Ribble Valley Borough Council
Council Offices
Church Walk,
Clitheroe
Lancashire
BB7 2RA

Phone: 0300 123 6780
Email: developeras@lancashire.gov.uk
Your ref: 3/2026/0587
Our ref: 3/2026/0587/HDC/KW
Date: 04 September 2026

Location: Plane Tree Farm Chipping Road Chaigley BB7 3LT
Proposal: Construction of an earth banked slurry lagoon and associated landscaping to include native species tree planting
Grid Ref: 367732 441971

Proposed Site Plan  
1:500 @ A3

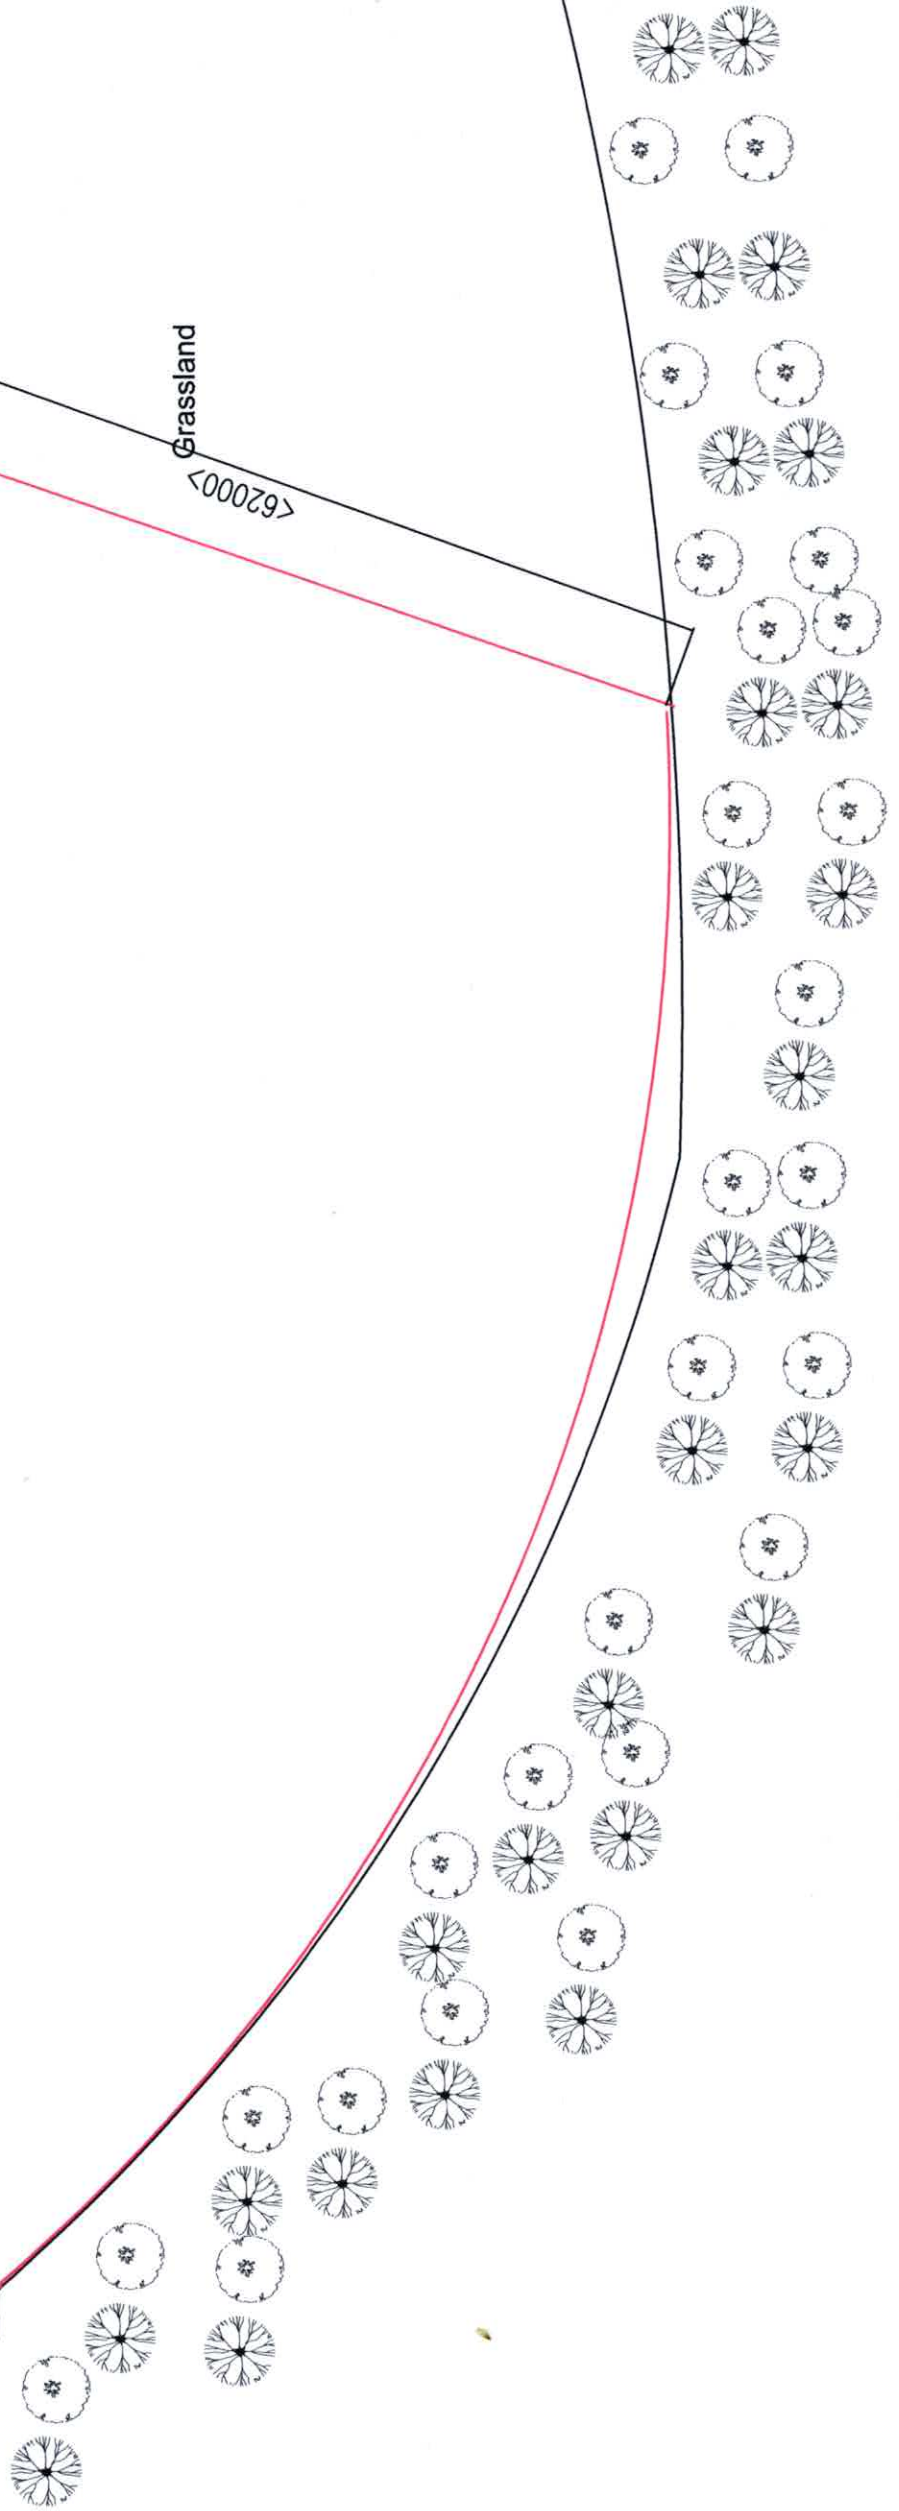
The site has an existing field gate access onto Chipping Road, classified as C354 and subject to a national speed limit. Agricultural access should be an appropriate width for the largest vehicle expected to access the site. The LHA therefore requests that a swept path analysis be provided showing the largest vehicle which will be accessing the site following the development without overrunning the verges.

A detailed site access drawing will be required showing the access hard paved for at least 10m into the site to prevent debris from being dragged onto the highway. Whilst the current access is gated, the LHA would look for any retained gates to be set back at least 10m from the carriageway edge.

The site access slopes towards the highway and, as such, the access should have a gradient of no steeper than 1:10 and should be provided with appropriate drainage to control surface water run off.

The access points to the highway maintained at public expense shall feature drainage, such as a drainage channel. Any surface water shall be collected within the site and drained to a suitable internal outfall.

Further information is required in the form of a swept path analysis demonstrating that the largest vehicle expected to access the site can safely enter and exit the development without overrunning the highway verge, together with a detailed site access drawing.

The access arrangement should include hard surfacing for a minimum distance of 10m from the carriageway edge, any retained gates set back at least 10m from the highway. Given that the access slopes towards Chipping Road, the gradient should be no steeper than 1:10 and suitable drainage provision should be incorporated to ensure that surface water is collected and managed within the site, preventing runoff onto the public highway.
